Re: Project Application for Fabcot Pty Ltd (Woolworths) Retail Facility at Warnervale Town Centre

As the owner of lands adjoining the southern boundary of the subject application, Landcom supports the orderly development of the Warnervale Town Centre and therefore wishes to provide comments on the project application and supporting documentation that has been prepared in relation to this project. We also refer to the Director General's requirements for MP 10_0195 dated 1st December 2010 (DGR's).

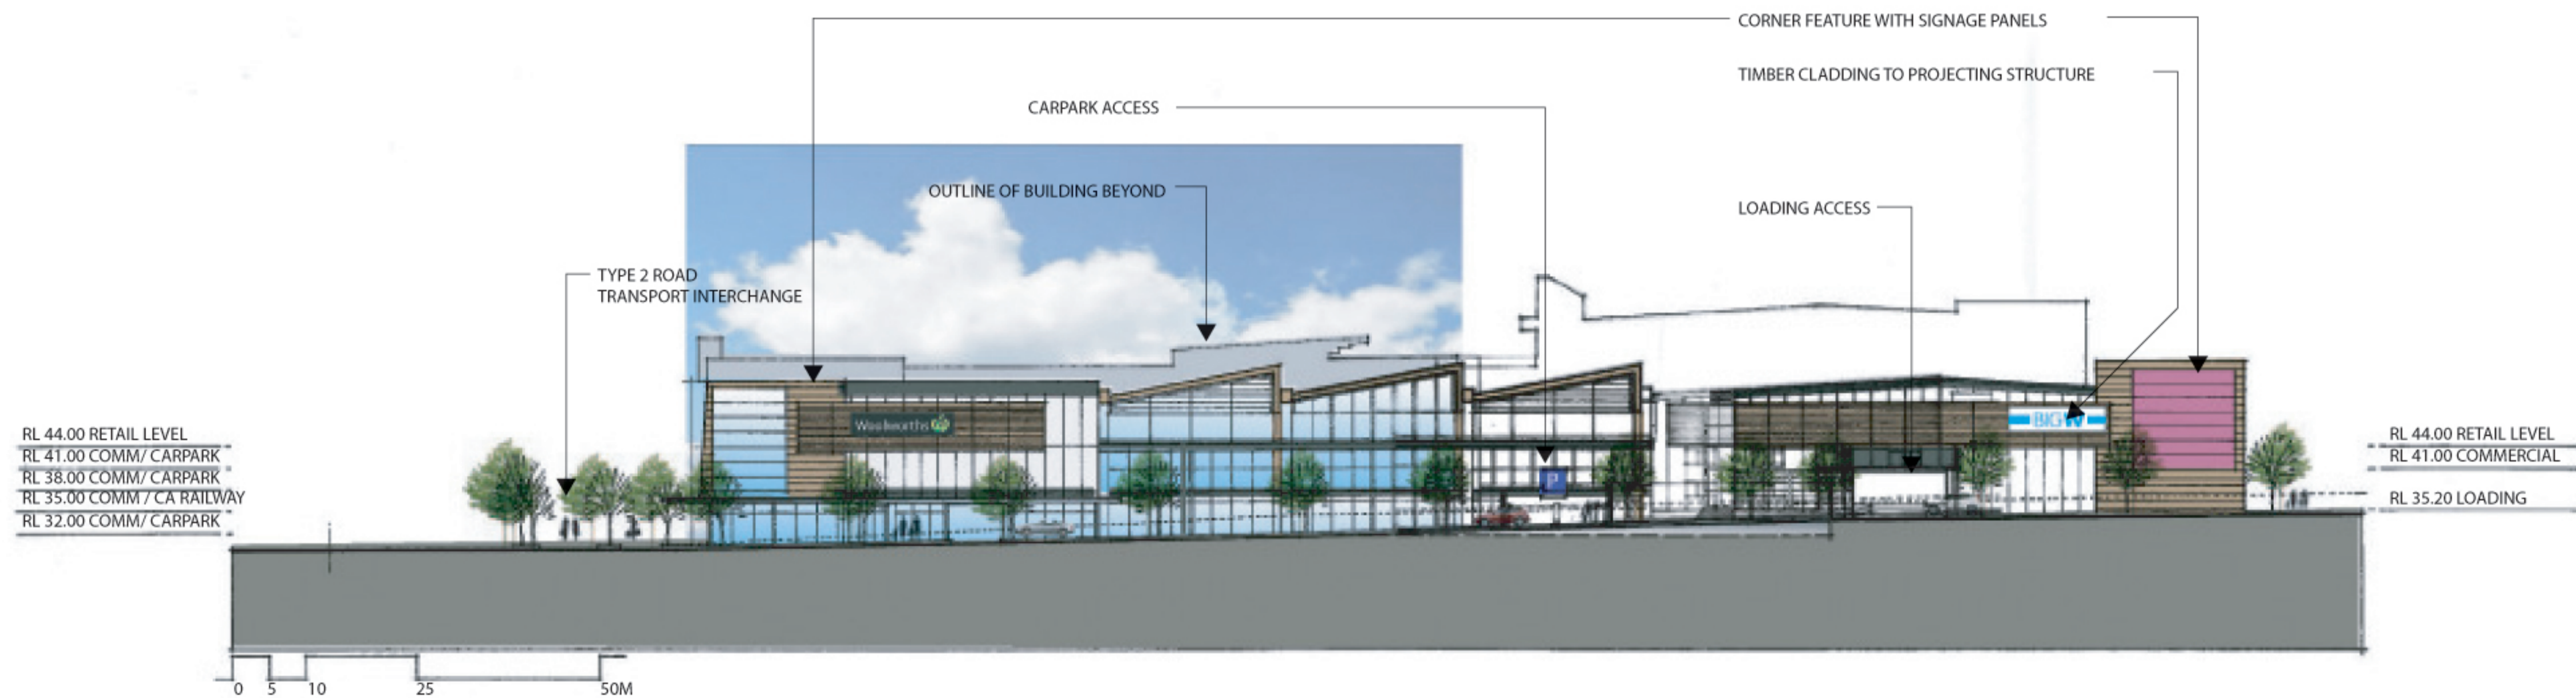
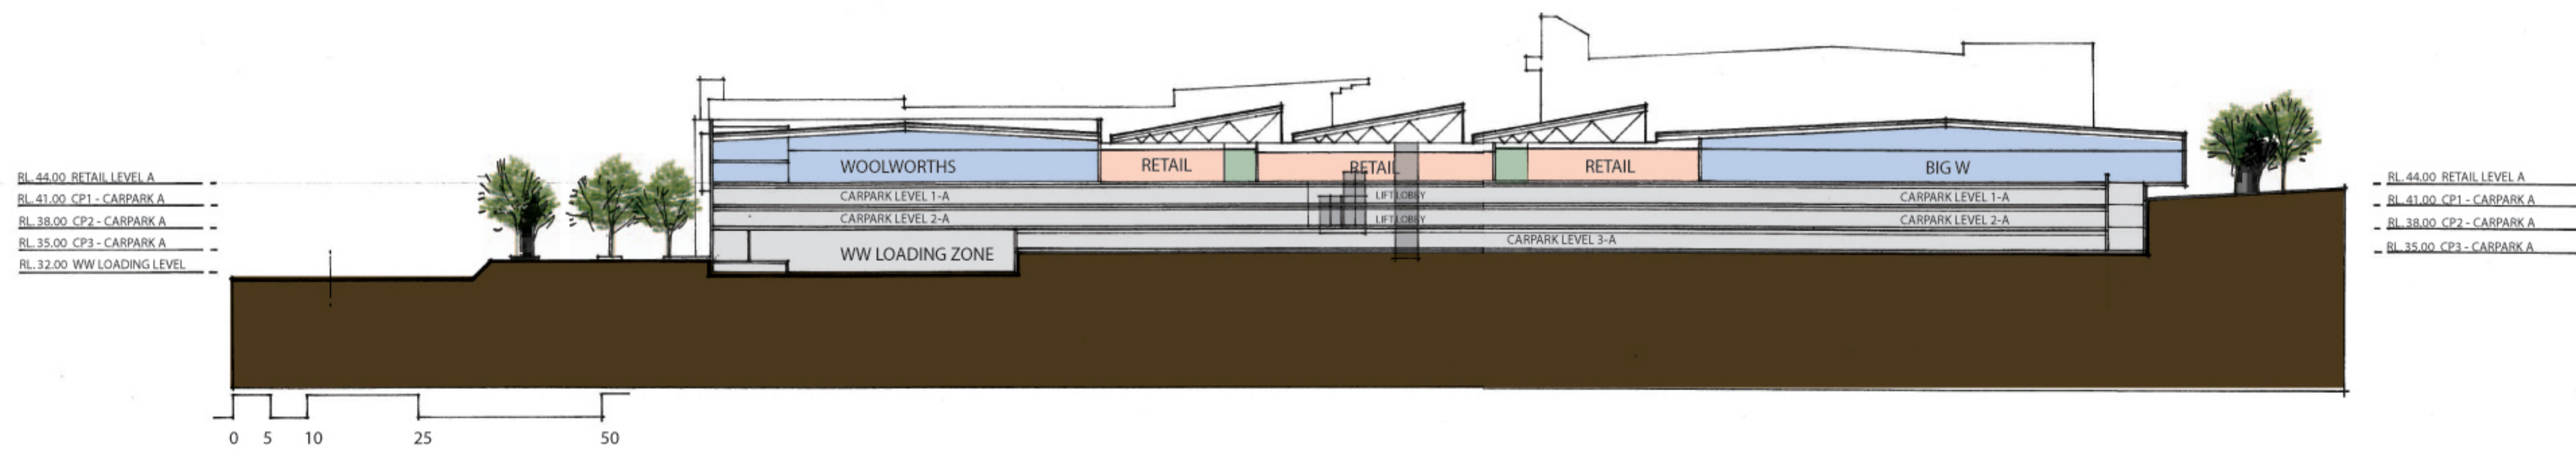
Comment: We refer to our comments above about the outdated street network used in this report. We are unable to find any detail sections and elevations of the bulk earthworks that are intended for the development of the site nor information about interfacing with adjoining streets. **It is therefore difficult to provide informed comment.**
